From: Martin Hill <Martin.Hill@arun.gov.uk>
Sent: 09 May 2022 17:42
To: Planning.Responses <Planning.Responses@arun.gov.uk>
Subject: RE: Planning Consultation on: LU/126/22/PD

Comments from Private Sector Housing:

Application No: LU/126/22/PD

Description of Works: Prior notification under Schedule 2, Part 3, Class MA for the change of use from shop (use class E) to dwelling (use class C3) on first floor.

Drawing
Existing elevations

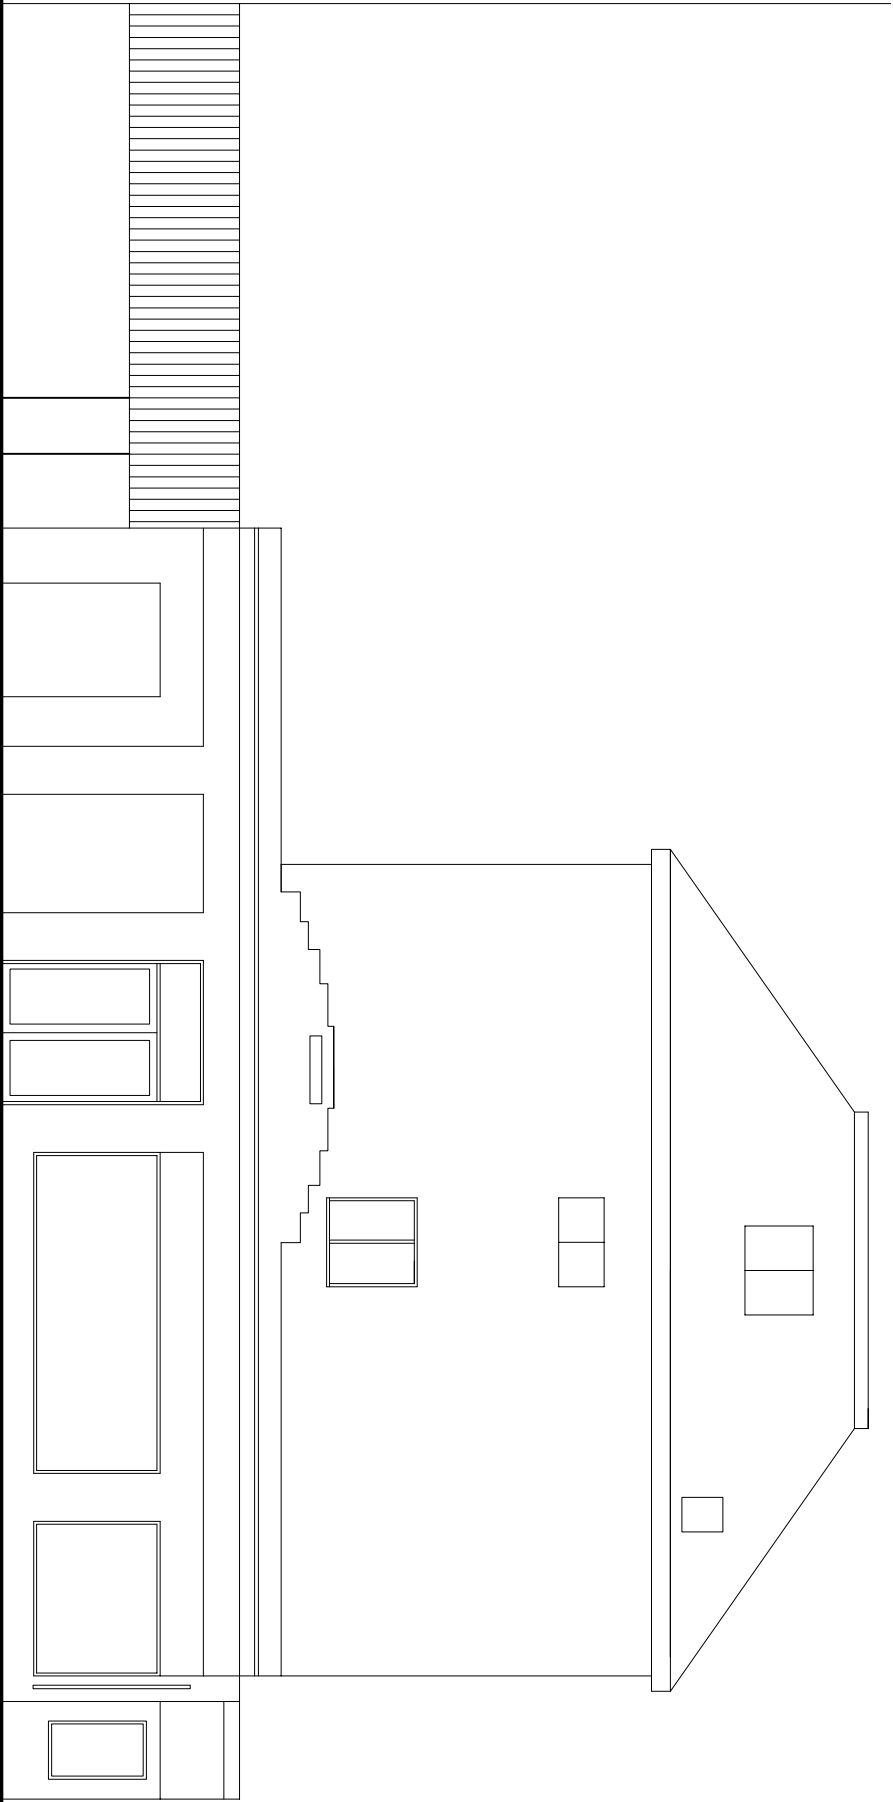
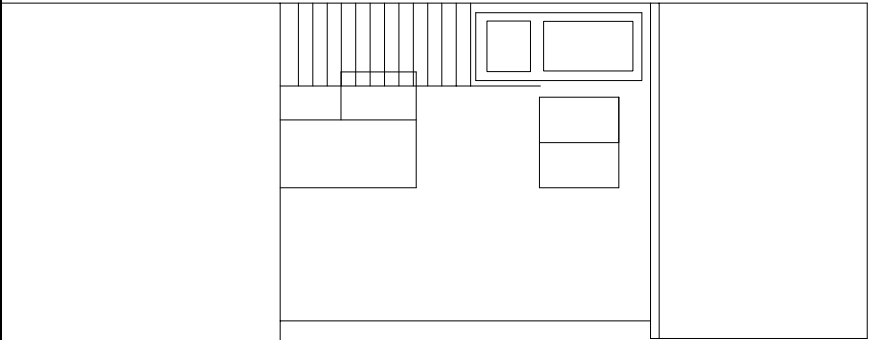
- The external staircases serving each flat are the means of escape from these flats down to ground level, therefore each must be protected from the effects of fire along each length. The sensitive area is 1.8m horizontally, therefore any windows in this region should be of fire resisting construction and fixed shut. Any doors in the sensitive area must be fire resisting and self-closing.

Drawing
Proposed First Floor Plan

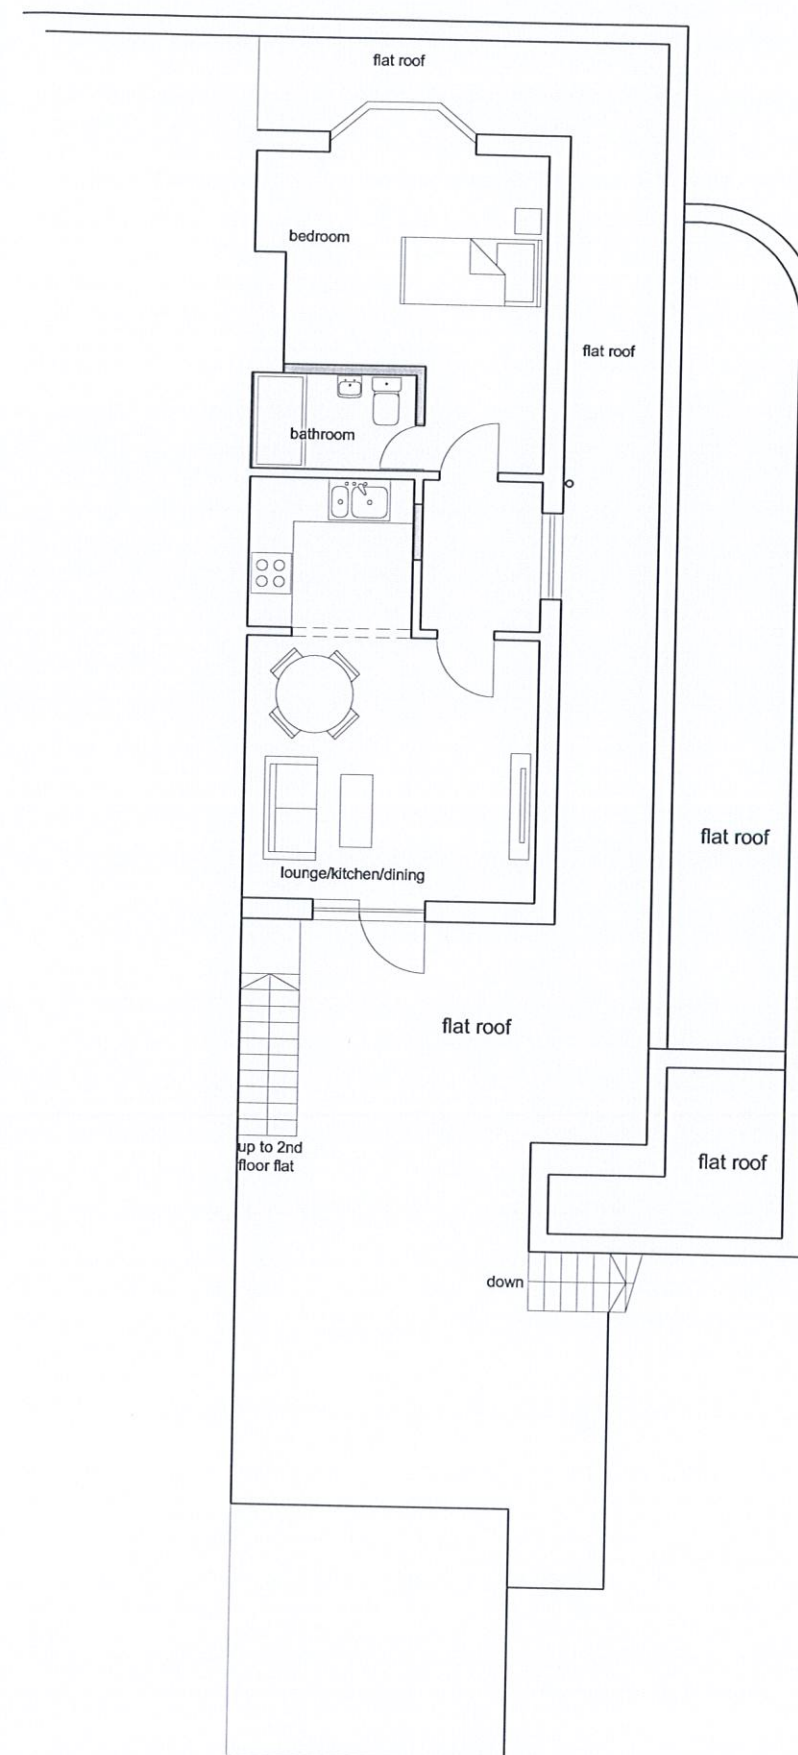
- A room where the only escape route is through another room is termed an “inner room” and poses a risk to its occupiers if a fire starts unnoticed in the outer room. The proposals suggest an inner, inner room due to a lobby area separating the bedroom and lounge areas. The escape route from the bedroom of the first floor flat is via the kitchen and lounge which are high risk areas. This can be overcome by relocating the flat entrance door to the designated window opening that lies in the lobby area between the lounge and the bedroom, to the side of the property on the first floor. Alternative options may include ensuring that the window in the bedroom meets the requirements of an escape window, with a 30 minute fire door separating the bedroom and lounge area and interlinked smoke detection serving the lounge, and the bedroom. The lobby should be removed because as per LACoRS guidance for inner rooms “nobody should have to pass through more than one inner room while making their escape”. However, this option is less desirable and consideration must also be given to the external escape route when exiting from the bedroom window and passing the lobby window situated between the lounge and bedroom areas; this is likely to be required as fire-resisting and be fixed shut.
